DOC17/461264
07_0127 MOD 5

Invincible Southern Extension Modification (07_0127 MOD 5) Draft Conditions

Review of Invincible Southern Extension Project (07_0127 MOD 5) Response to Submissions

Figure 1: Existing Biodiversity Offset Areas

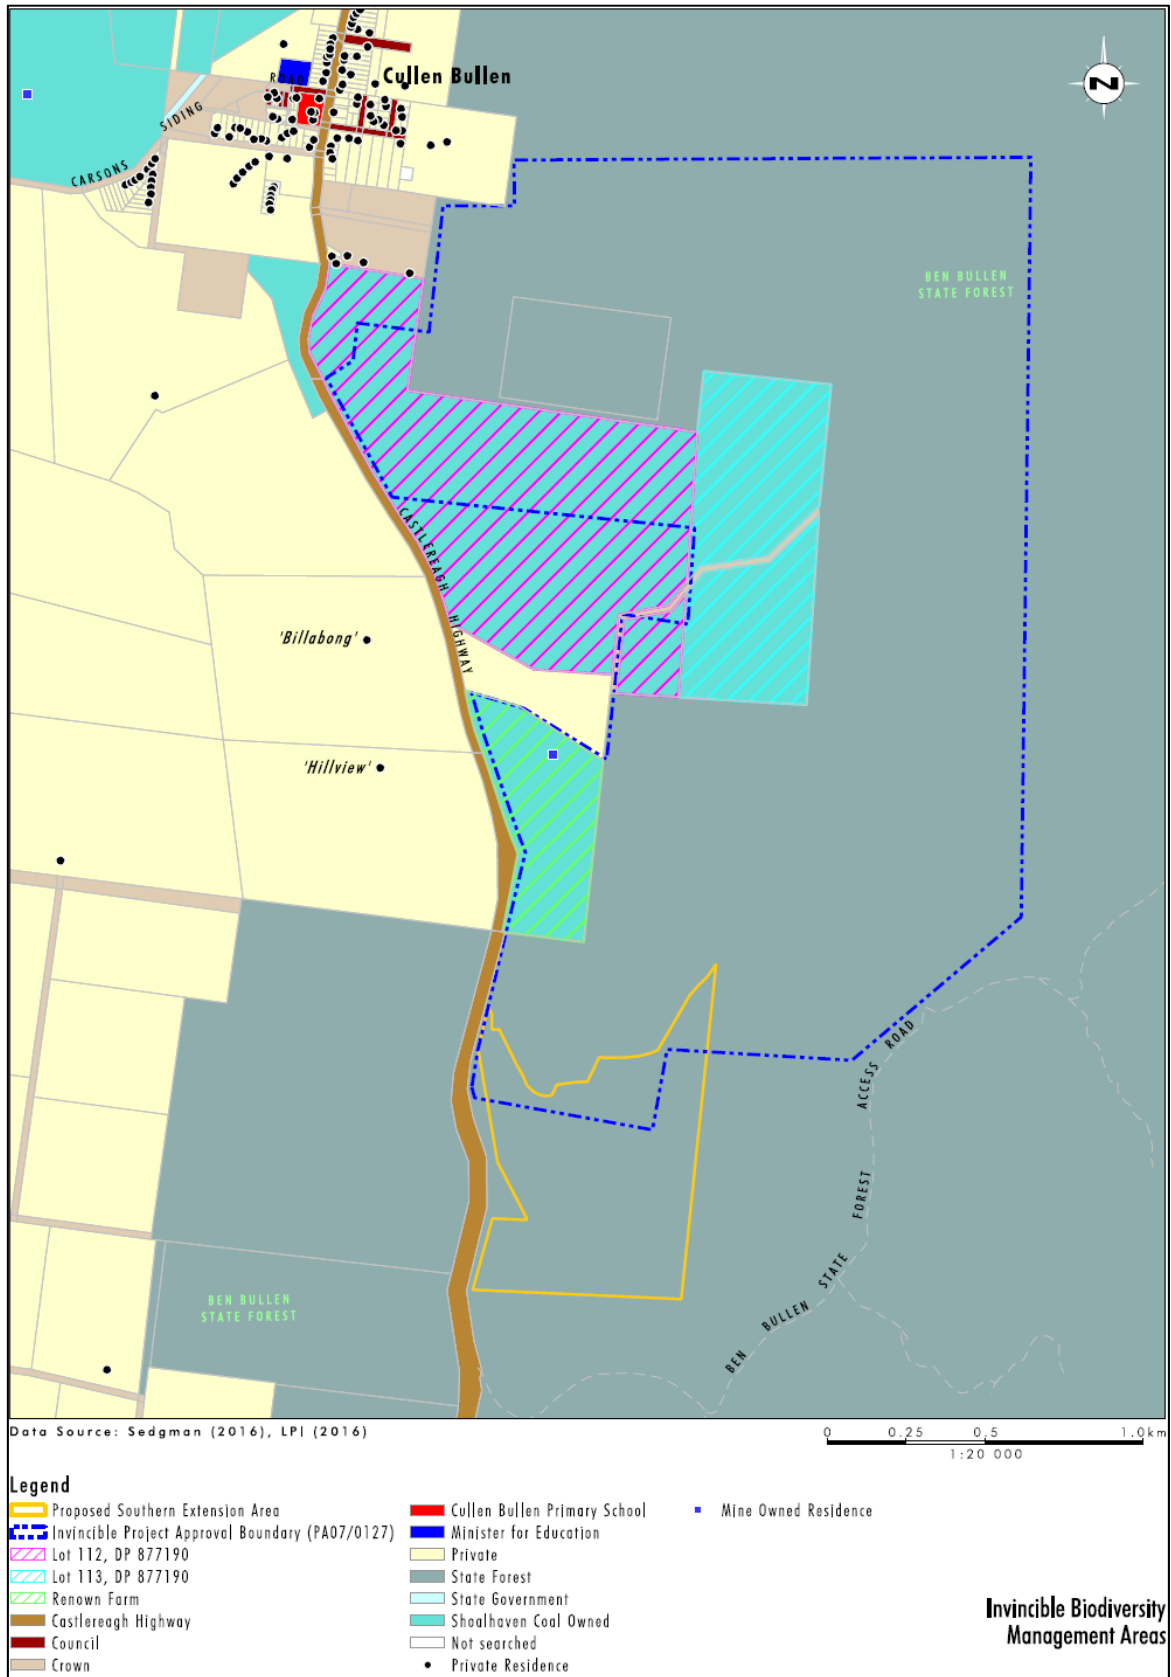
We suggest that references to "Hillcroft Biobanking Site" in Table 7, Condition 32, and Figure 2 in Appendix 5 are referred to as "Hillcroft offset site". We note that the condition relating to Table 7 should be numbered as "29" rather than "g". Also, the offset sizes in Table 7 do not align with the areas listed in Figure 1 in Appendix 5.
